Date: 18-Jan-2024
Our Ref: 2023/93276

**Application for Approval of Details Reserved by Condition
Town and Country Planning Act 1990
Planning (Listed Buildings and Conservation Areas) Act 1990**

Discharge conditions 3 (materials), 4 (improvements to access track and parking), 5 (waste collection) on previous permission 2021/94676 for erection of extensions and alterations to convert existing pig sty, domestic storage and WC building to single dwelling

**Hey Knowle Farm, Linfit Lane, Linthwaite, Huddersfield, HD7 5LF
Application Number: 2023/93276**

title Site plan and location plan
number 20141D-05-P04
scale 1:200, 1:100 and 1:1250
size A1

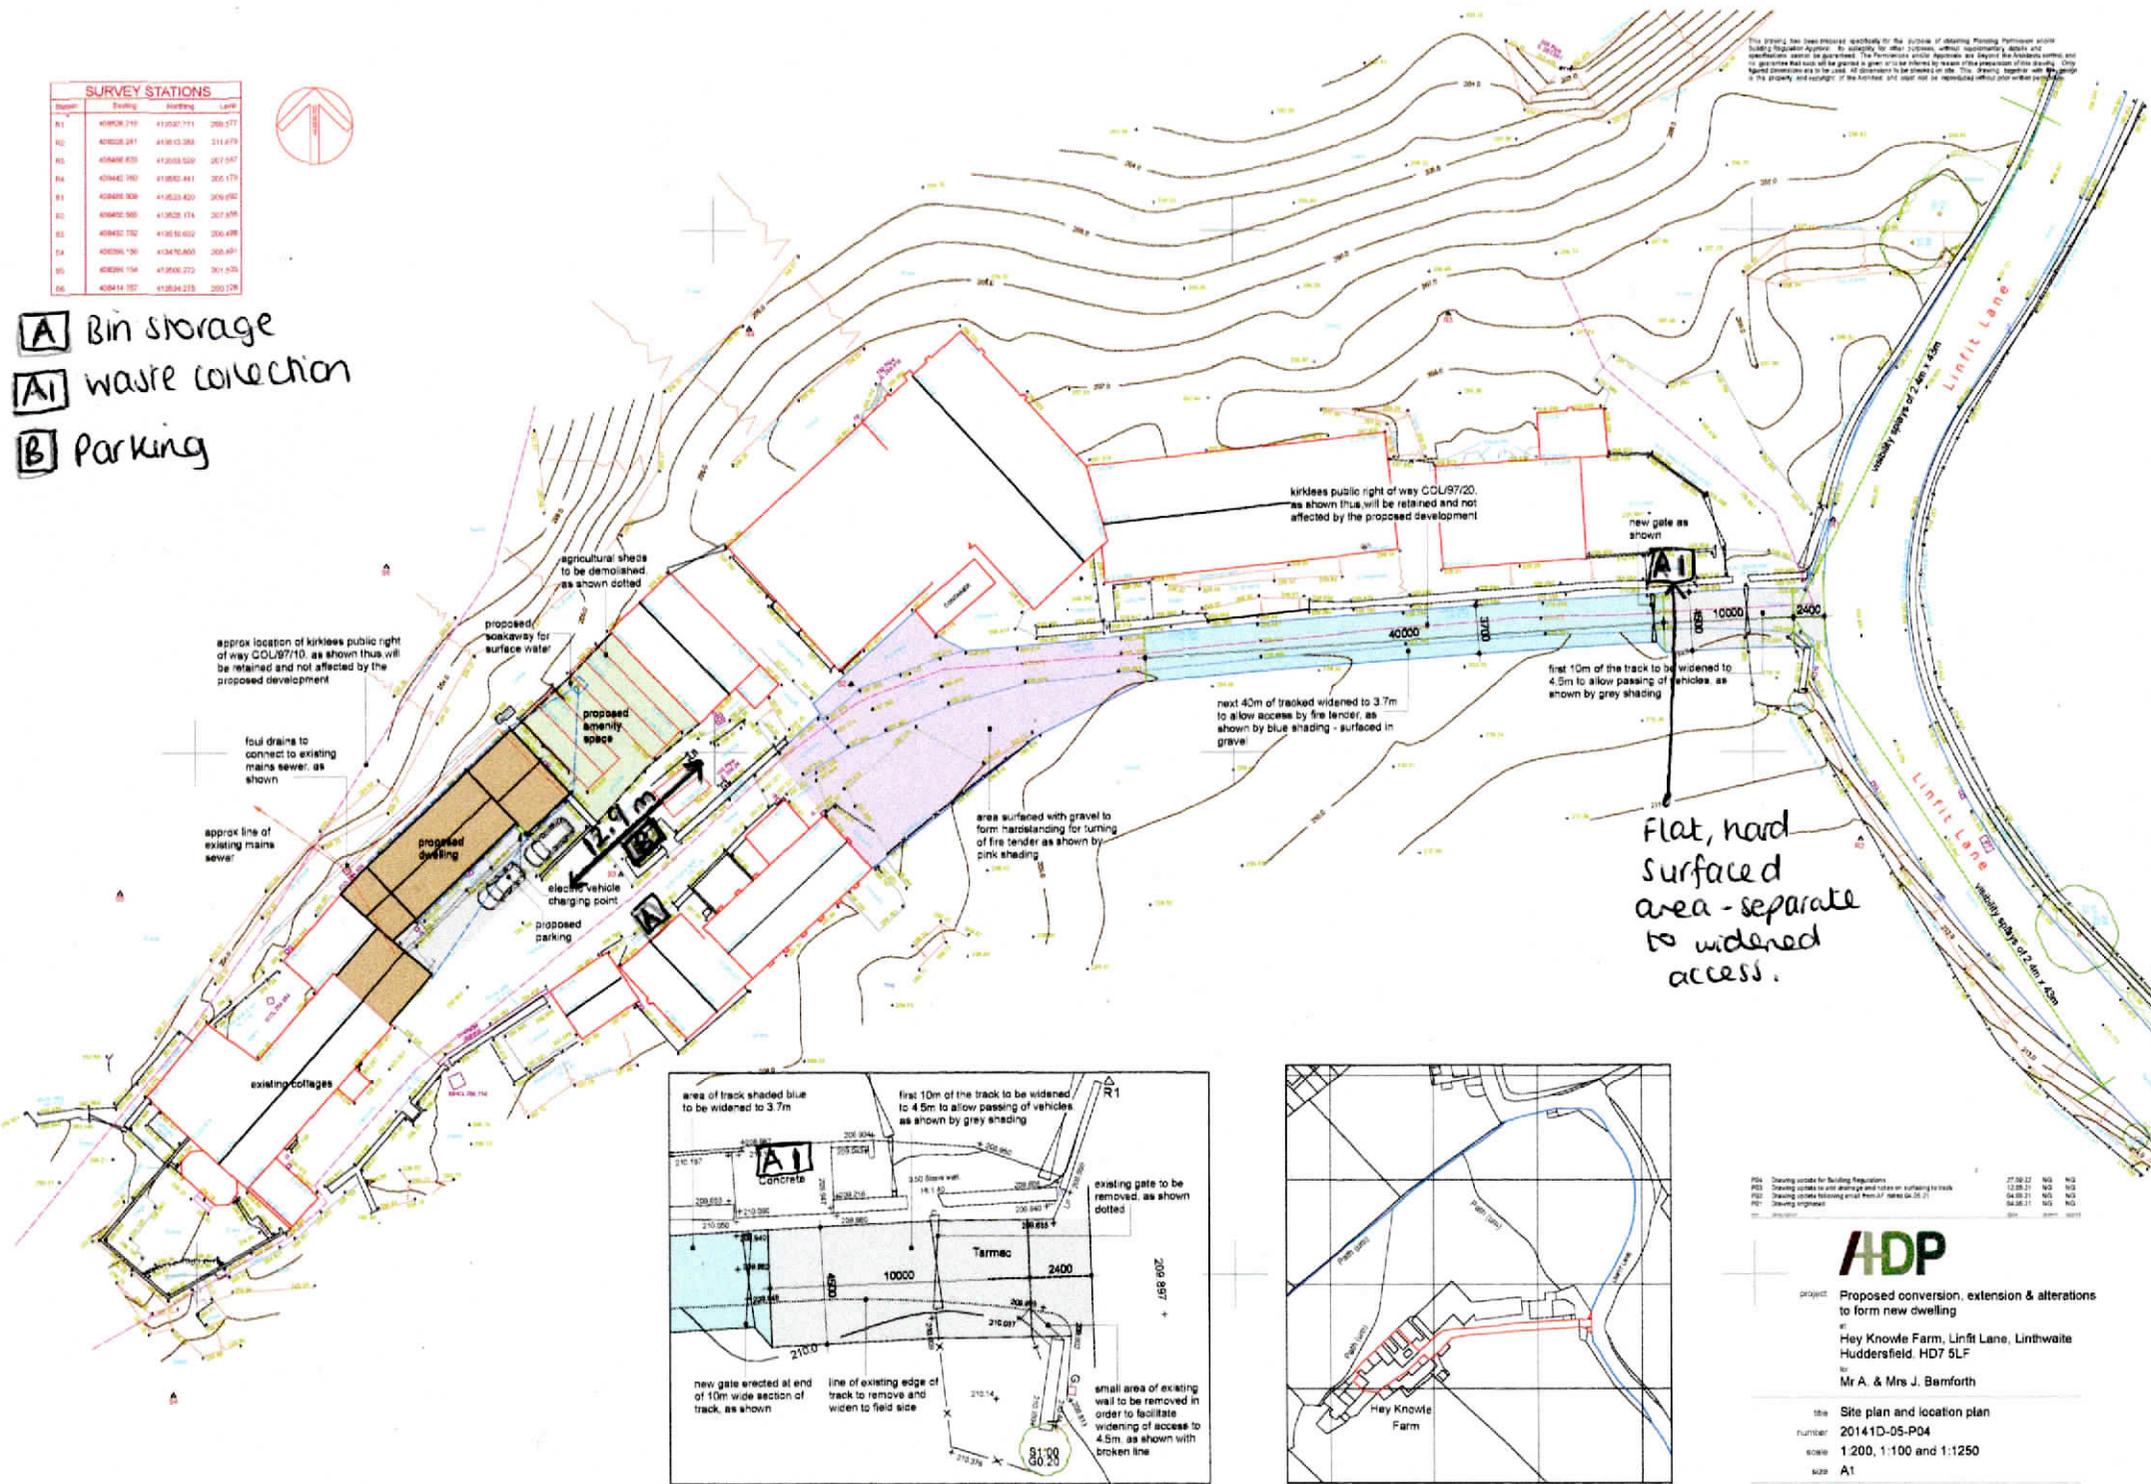
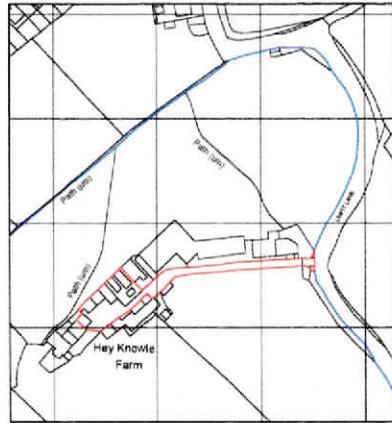
The supporting statement and plan 20141D-05-P04 indicate that:

- The lane will be widened, excavated to a depth of 650mm, then filled with sandstone hardcore and finished with compacted tarmac plainings.
- Cars to be parked as shown at points B on adapted site plan showing in a black line that the removal of a temporary shed has made space for two car parking sites adjacent to the proposed amenity space.

The site plan shows three squares, sketched on in black pen, one labelled 'A' and two labelled 'B'. The supporting statement claims that waste bins, both green and grey, will be stored and collected from point 'A' on the adapted site plan 20141D-05-P04 as per the waste bins from Hey Knowle Farm and Hey Knowle Farm Cottage.

The case officer has discussed these arrangements with the Waste Operations Manager who has stated that bin collection for the existing dwelling is from the site entrance, and has advised that it is unlikely, in view of current standards and practice, that bin collection crews would be able to collect from point 'A' or 'B' as shown on the plans.

This condition cannot be discharged at the present time.

The squares indicated 'B' are however deemed acceptable as bin storage points for the two new dwellings.

It is therefore recommended that the plan and supporting statement be amended to show:

- The two areas marked 'B' designated as bin storage points for the new dwellings.
- The bin collection point on the access track just in from the junction with the adopted highway so that it does not obstruct the highway but is easily accessible.
